Thank you for consulting me on the above application, I have reviewed the amended plans, and can see that several points raised by my colleague, Ian Carmichael, still have not been addressed. I provide these comments below;

Kevin Cox | Crime Prevention Design Advisor | Oxford City, Cherwell, Vale of White Horse, South and West Oxfordshire  
Address Thame Police Station, Unit 2, Thame Park Business Centre, Thame, Oxfordshire OX9 3XA

On Behalf of the CPDA Team, Thames Valley Police

Land to rear of George Pub Littlemore	Date:	01/10/2020
KJD Investments	Scale:	1:100@A3
Units 6 & 7	Status:	Preliminary
Proposed Elevations	Drawn:	JR
190277 - A - 05 - 203	Revision:	C

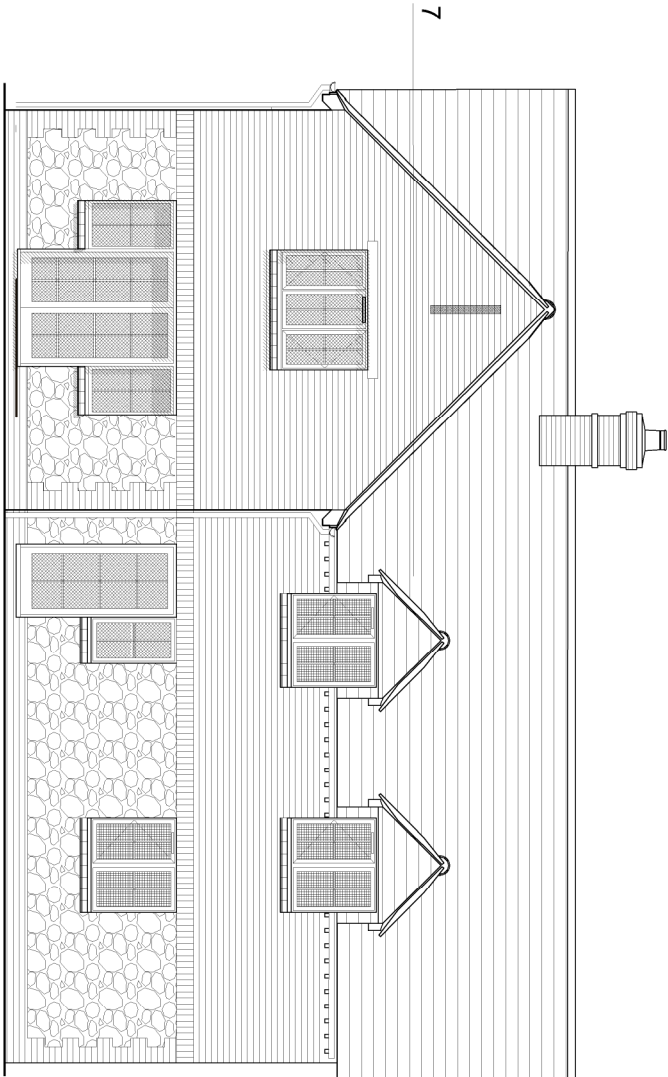
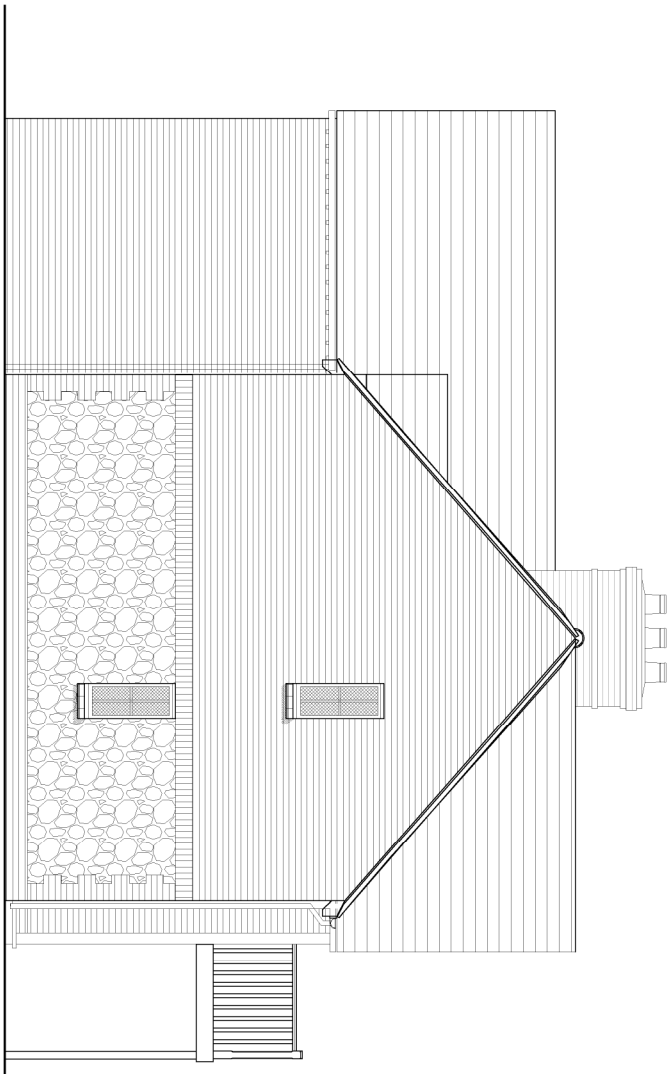
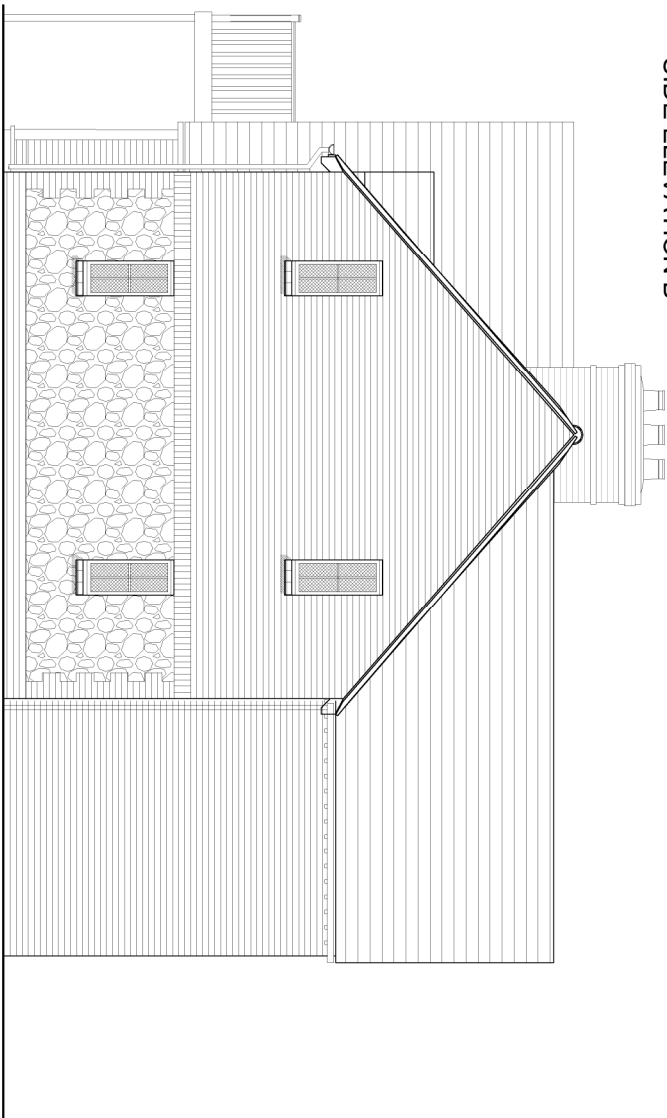
- There is very little natural surveillance from any of the dwellings over the access route, or the parking area next to plot 1 and between plot 3 and 4. I recommend that the internal layout of dwellings is revisited with a view to providing more windows of active rooms overlooking these spaces to remedy this situation. Side elevation windows of active rooms must be provided at Plots 1, 3 and 7 regardless.
